Our Ref: LU/339/20/NMA

Non material amendment following the grant of LU/121/17/RES for alterations to approved door positions.

Plot 121, Phase 2 Land North of Toddington Lane Littlehampton BN17 7PP

Drawing Title:
WPLTH3520A and WPLTH3520C
Proposed Plans - Plot 121

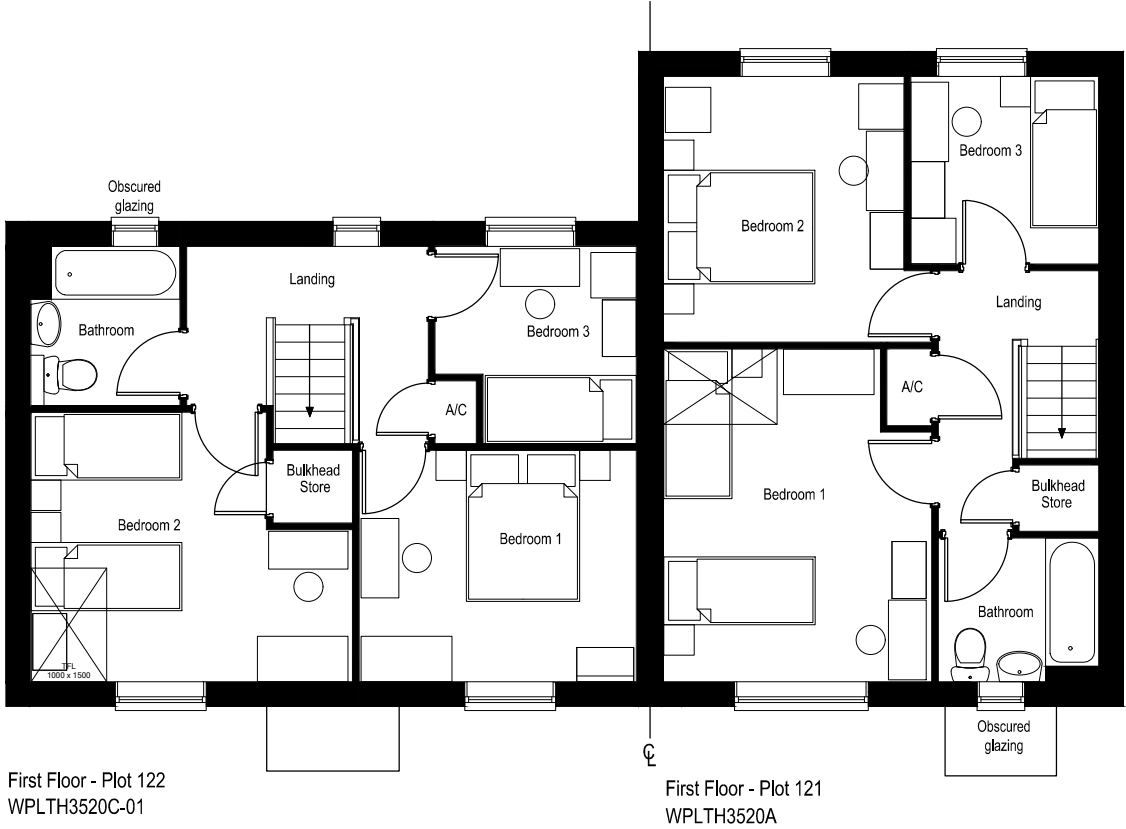
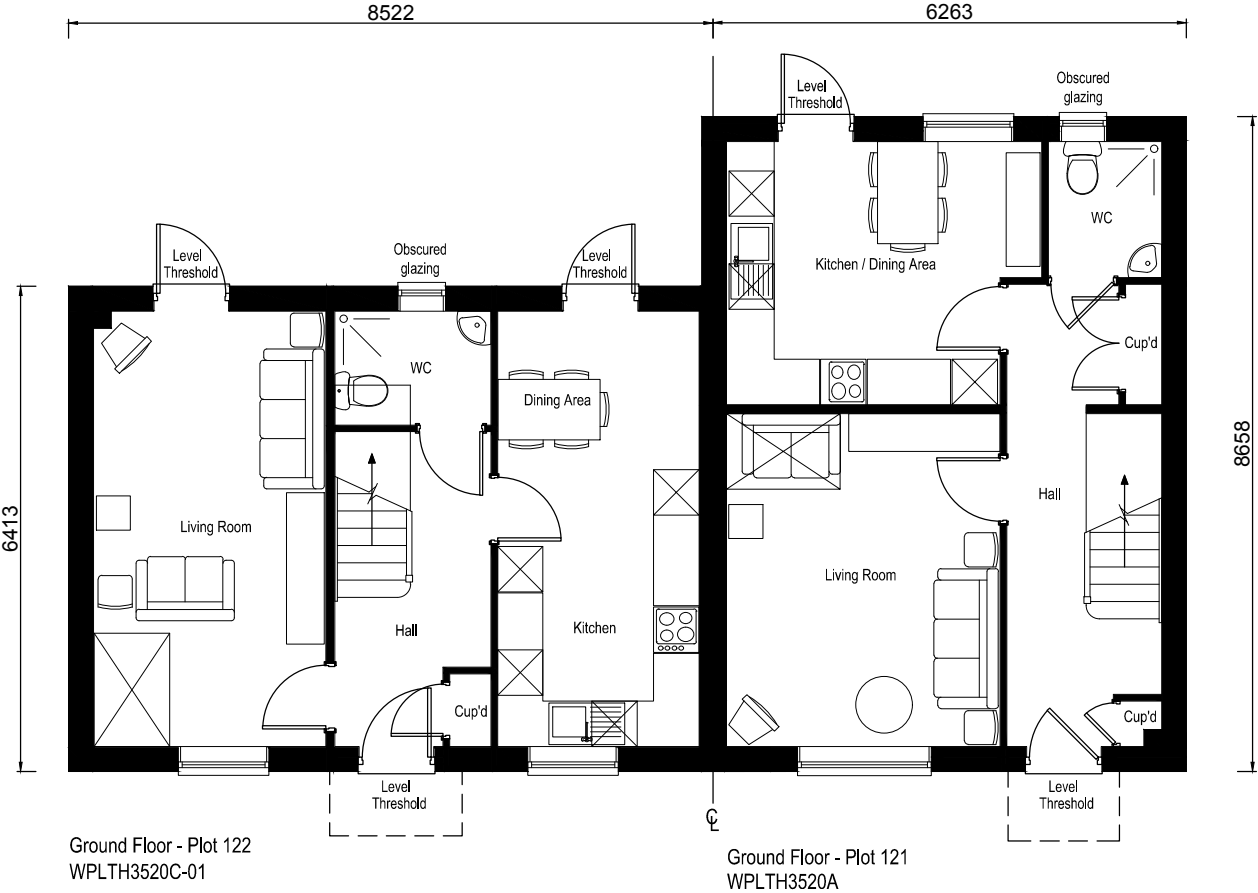
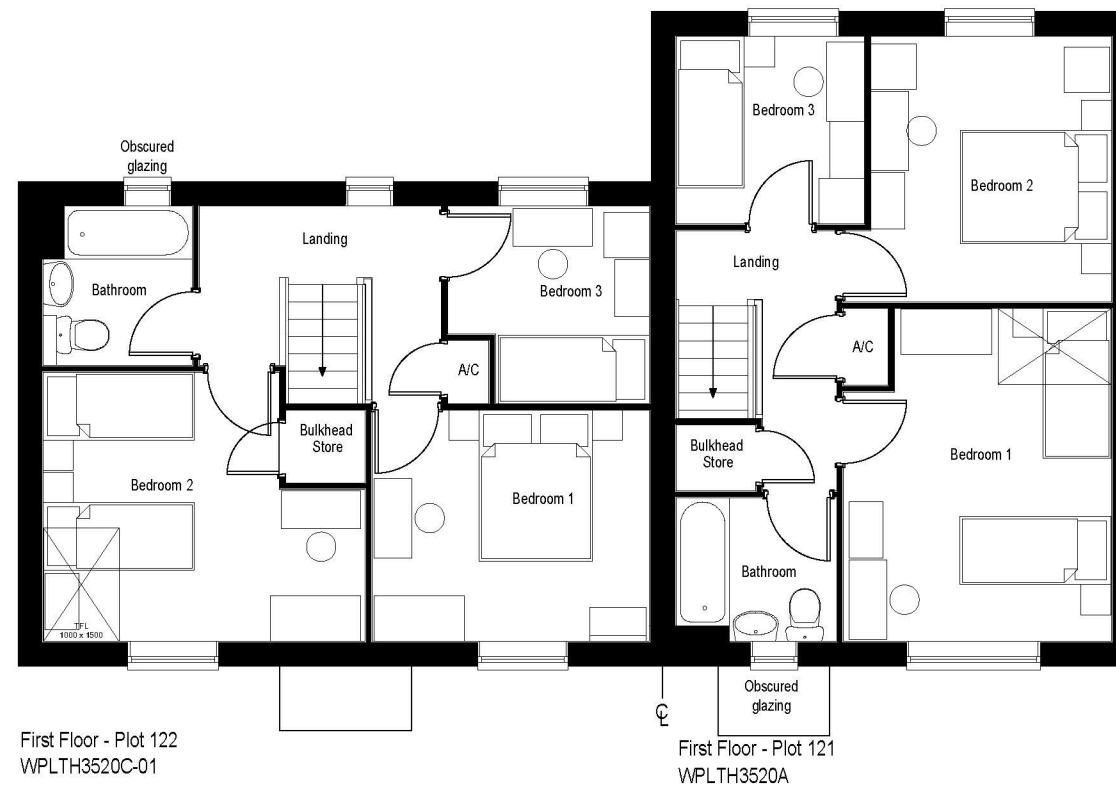
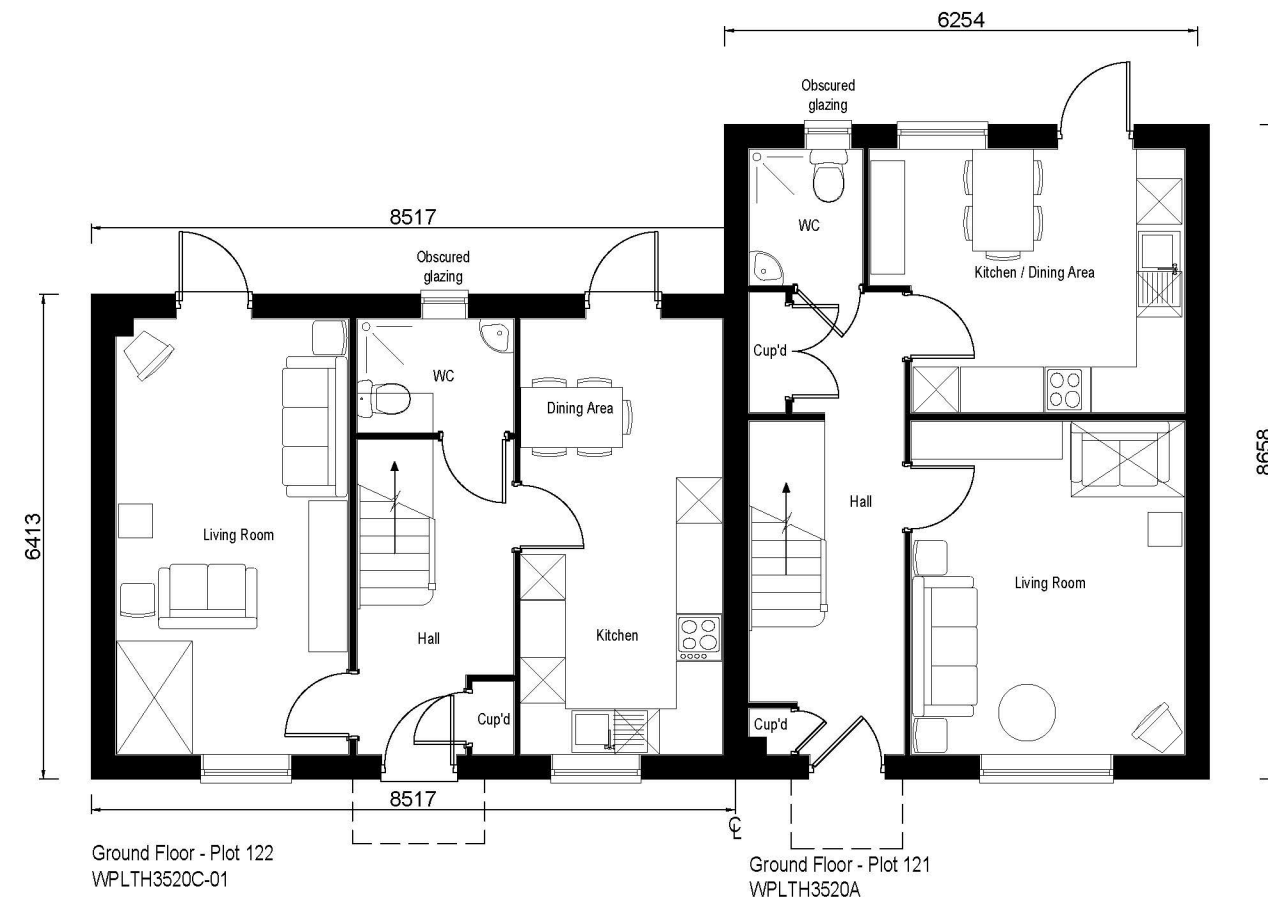
The reason that this proposal has been accepted as a Non-Material Amendment is because it regularises a change on site which has the front door to Plot 121 situated on the right hand side of the house (the approved drawings show the front door on the left hand side of the house) in Persimmon Homes Phase 2 at Hampton Park, and it can therefore be considered under section 96A of the Town and Country Planning Act 1990.

From the information submitted I am prepared to take the alteration to the front elevation of Plot 121 as a Minor Amendment to the reserved matters approval (LU/121/17/RES) - for Persimmon Homes Phase 2 at Hampton Park.

Please note that Drawing No. 543_PL_APP4_WPLTH_P_100 - WPLTH3520A and WPLTH3520C Proposed Plans - Plot 121, Drawing No. 543_PL_APP4_WPLTH_E_200 - WPLTH3520A and WPLTH3520C Proposed Elevations - Plot 121, Drawing No. 543_PL_APP4_001 - 4th NMA Application Site Layout - Plot 121 and Drawing No. 543_PL_APP4_100 - 4th NMA Application Site Layout - Plot 121 now form part of the approved planning documents and drawings for the reserved matters
